ADC PARKS & GREENSPACE ARBORICULTURE

PLANNING APPLICATION: FP/227/14/T

ADDRESS: The Green, the Ridgeway Felpham Beach Estate Felpham

BRIEF DESCRIPTION: Surgery to various trees

Advice taken from a TPO-Registered Tree Surgeon 13/12/14:

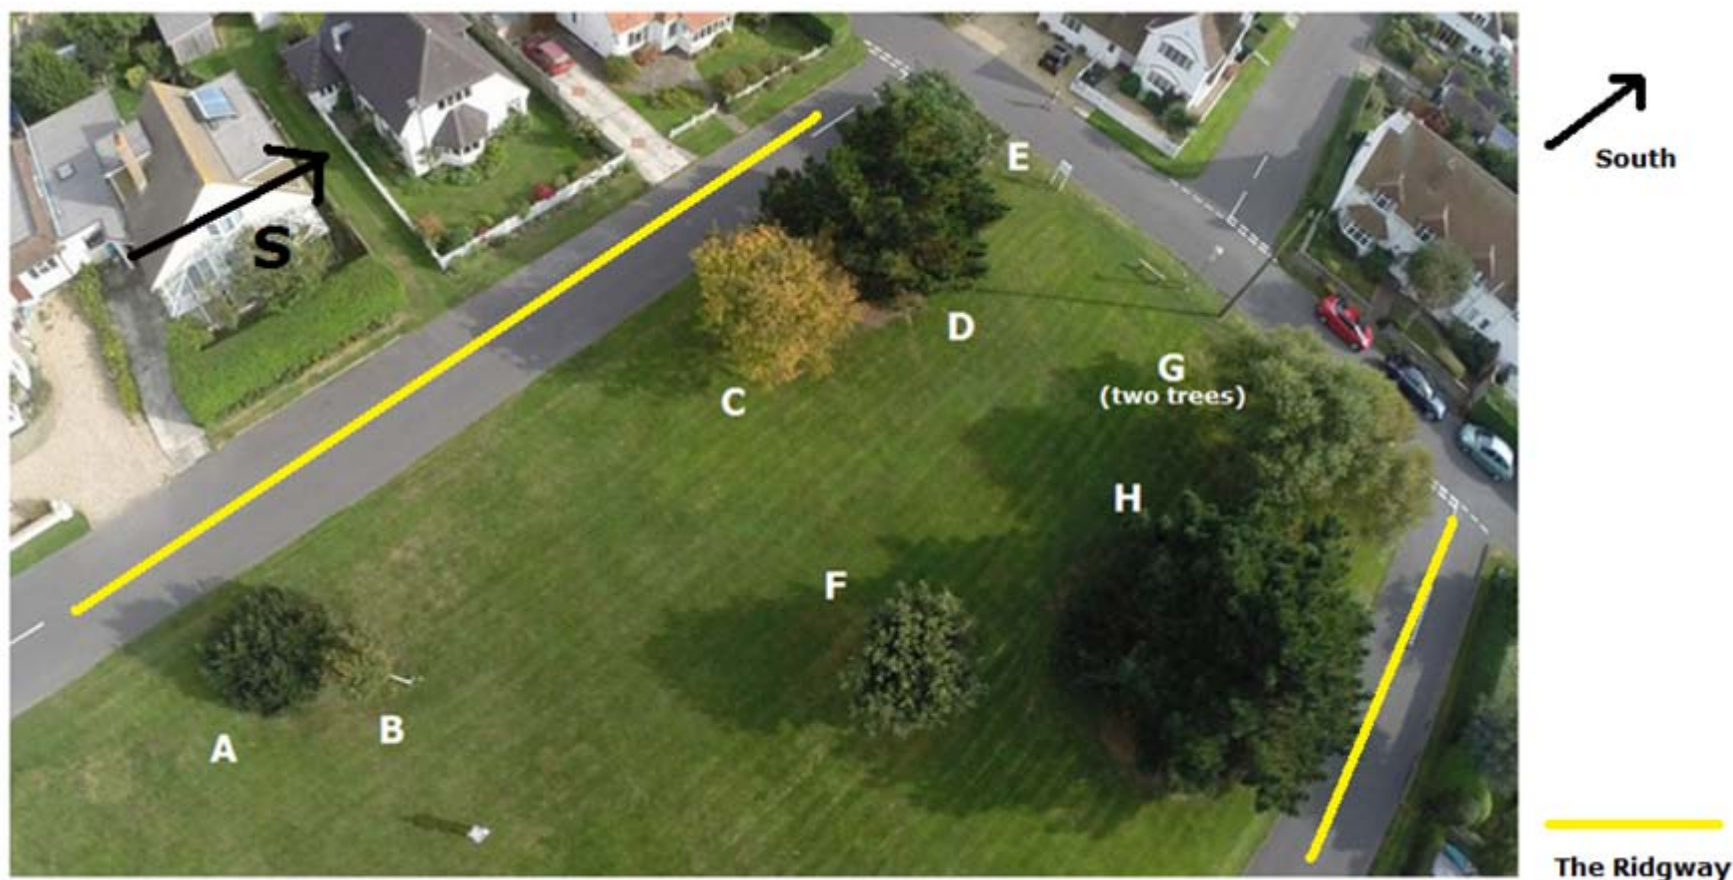
- The applicant has requested the removal of the lowest east facing branch at 1.5 meters height form **T1**. Competition of this pruning operation is unlikely to have any overall effect on **T1**'s longevity and/or form, as removal this lowest branch is likely to rebalance this individual. Also noted on the site inspection was the extensive abiotic damage that has been sustained to the Basal area (most likely causes of this abiotic damage is conflict with mowers/strimmer's). This tree is not covered by an active TPO order.

- For **T2**, the applicant has requested to reduce the tree by 1.2 meters and remove a branch overhanging the road. From the site inspection it is clear that this tree has particular poor form, as it the main stem has lent over in an eastern direction. As for the 'branch to be removed over the road', the site inspection did not reveal a specific branch that spanned over the road. Moreover, the requested reduction of 1.2 meters will alleviate any potential conflict with highway users. This tree does have evidence of previous pruning (possibly a reduction). Also **T2** is subject to TPO order.

- For **T3**, the applicant has requested to reduce the tree by 1.2 meters and remove a branch overhanging the road. From the site inspection, it is apparent that **T3** is in a much better form than **T2**, but does have less presence in the wider landscape. Again for the 'branch to be removed over the road', the site inspection identified a number of individual limbs

that would meet that profile. It is also clear the requested reduction of 1.2 meters will alleviate any potential conflict with highway users. This tree does have evidence of previous pruning (possibly a reduction). Also **T3** is subject to TPO order.

- For **T4**, the applicant has requested to fell this individual. It is clear from the site inspection that this tree has poor form, as the main stem has a heavy lean to the north east at about 2 meters height. It was also apparent that a large amount of the crown mass appears to be dead (over 70%). It is also apparent that there is interference between **T4** and **T5**, which is causing suppression (especially **T4**). **T4** is currently not covered by a TPO order.

- For **T5**, the applicant has requested to reduce the tree by 1.2 meters. This tree does have a lean to the north (due to the prevailing wind). The proposed reduction of 1.2 meters will remove the end weight from the canopy, which considering **T5**'s lean is likely to increase the retention span of **T5**. Also **T5** is subject to TPO order.

- For **T6**, the applicant has requested to crown lift the tree by 2 meters. This action is unlikely to be a detriment to the aesthetic value and/or longevity of **T6**. This tree is not covered by an active TPO order.

- For **T7**, the applicant has requested to crown lift the tree by 2 meters and reduce the lateral spread by 2 meters. The lateral spread is beginning to encroach the main highway, the desired reduction will alleviate this interference. Also **T7** is subject to TPO order.

- For **T8**, the applicant has requested reduce the lateral spread by 2 meters of the roadside only. The lateral spread of **T8** is beginning to encroach the main highway; the desired reduction will alleviate this interference. Also **T8** is subject to TPO order.

- For **T9**, the applicant has requested to remove a branch spanning of the roadside. This branch is beginning to encroach the main highway; the desired reduction will alleviate this interference. Also **T9** is subject to TPO order.

- For **T1**, I would have no objection to the proposed operation. No conditions to be set, as this tree has not got an active TPO.
- For **T2**, I would have no objection to the proposed operation of reduce the tree by 1.2 meters and remove a branch overhanging the road only. **The following conditions are to be adhered to;**

- For **T3**, I would have no objection to the proposed operation of reduce the tree by 1.2 meters and remove a branch overhanging the road only. **The following conditions are to be adhered to;**

- For **T4**, I would have no objection to the applicants request to fell **T4**. No conditions to be set, as this tree has not got an active TPO.
- For **T5** I would have no objection to the proposed operation of reduce the tree by 1.2 meters only. **The following conditions are to be adhered to;**

- For **T6** I would have no objection to the proposed operation of a crown lift of 2 meters. No conditions to be set, as this tree has not got an active TPO.

- For **T7** I would have no objection to the proposed operation of crown raising **T7** by 2 meters, and to reduce the tree by 2 meters only. **The following conditions are to be adhered to;**

- For **T8** I would have no objection to the proposed operation of reduce the lateral spread spanning towards the highway, by 2 meters only. **The following conditions are to be adhered to;**

- For **T9** I would have no objection to the proposed operation of reduce the lateral branch spread spanning towards the highway only. **The following conditions are to be adhered to;**
